SECTION 73 APPLICATION IN RELATION TO PLANNING APPLICATION N/001/01906/23

ERECTION OF 2 NO. DWELLINGS, GRIFFONTEE HOUSE, MAIN ROAD, ABY, ALFORD, LN13 0DQ

Project	Proposed Dwellings	
Location	Main Road, Aby	
Drawing Title	Plot 2 Elevations	
Status	Planning (Reserved Matters)	
Date	25.09.2023	
Scale	1:100 @ A3	
Drawing No.	48923-106	Rev B

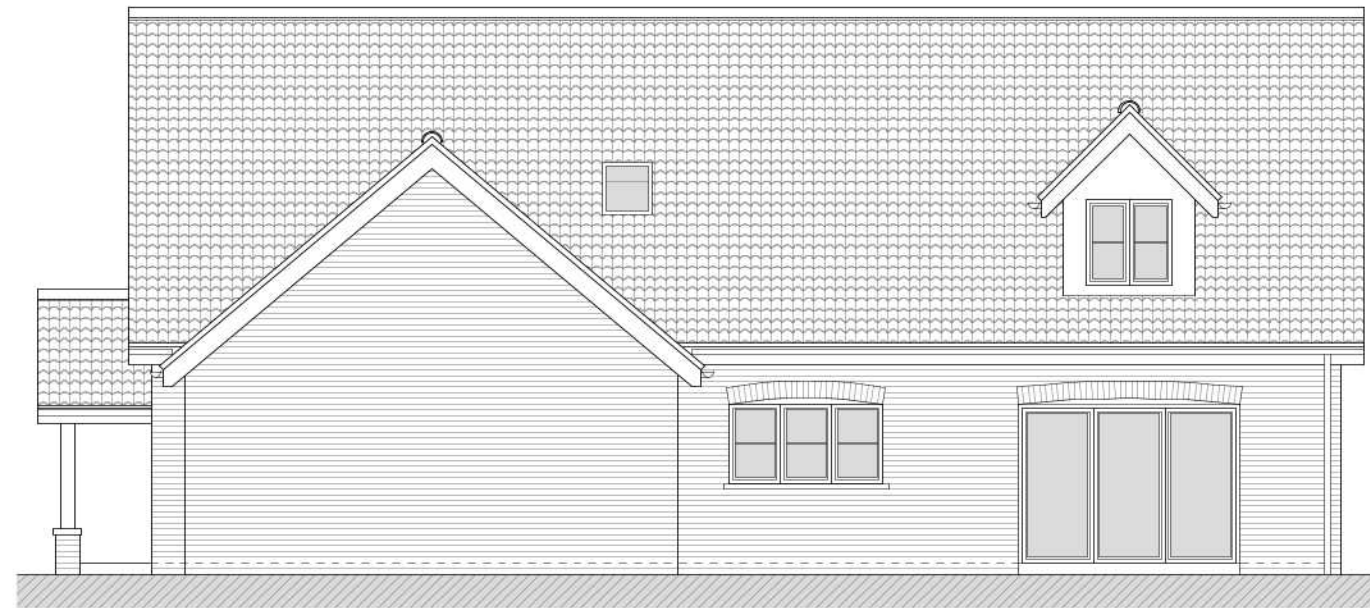
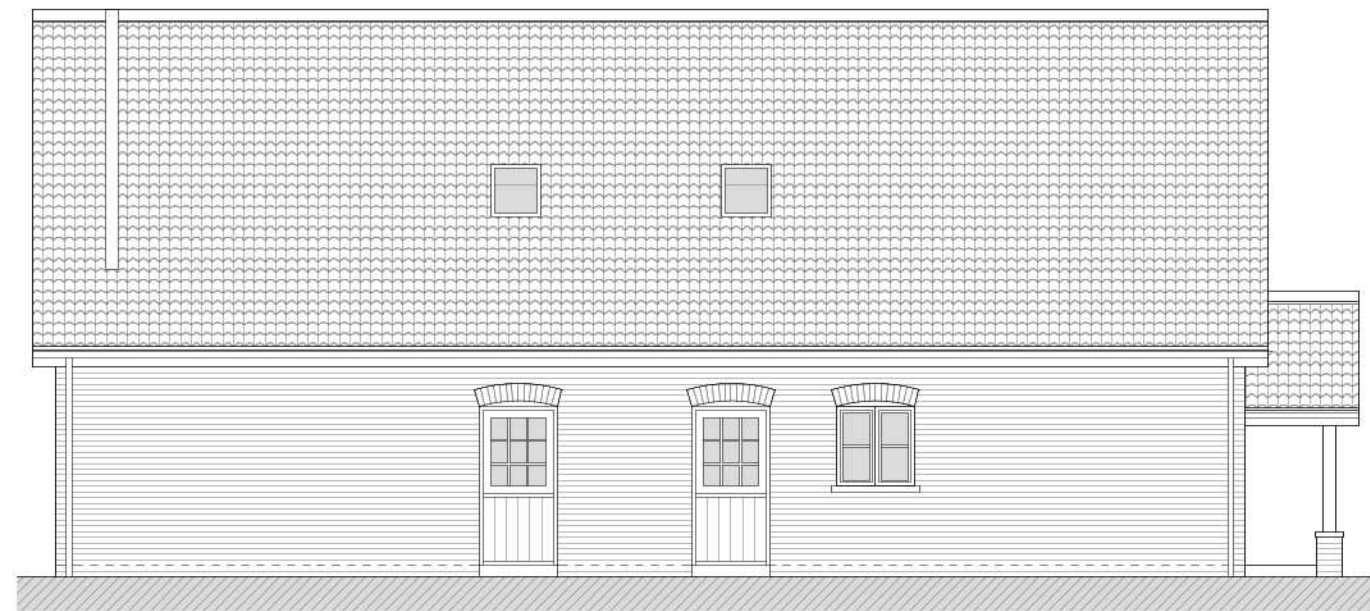
Please find enclosed a S73 application which seeks to vary the wording of Conditions 1, 2 and 3 imposed on planning application reference N/001/01906/23. The variations are proposed to allow minor changes to the design of the dwelling on Plot 2 (mainly the removal of the chimney and plinth brick detail) and to discharge conditions 2 (materials) and 3 (landscaping).

Condition No. 2 requires details of the materials used in the construction of dwellings and hard surfaced areas. Details for both plots have been submitted as part of this application (see drawings 48923-104 Revision A and 48923-106 Revision B). It is therefore proposed that the condition be amended to ensure that the development proceeds in accordance with these details.
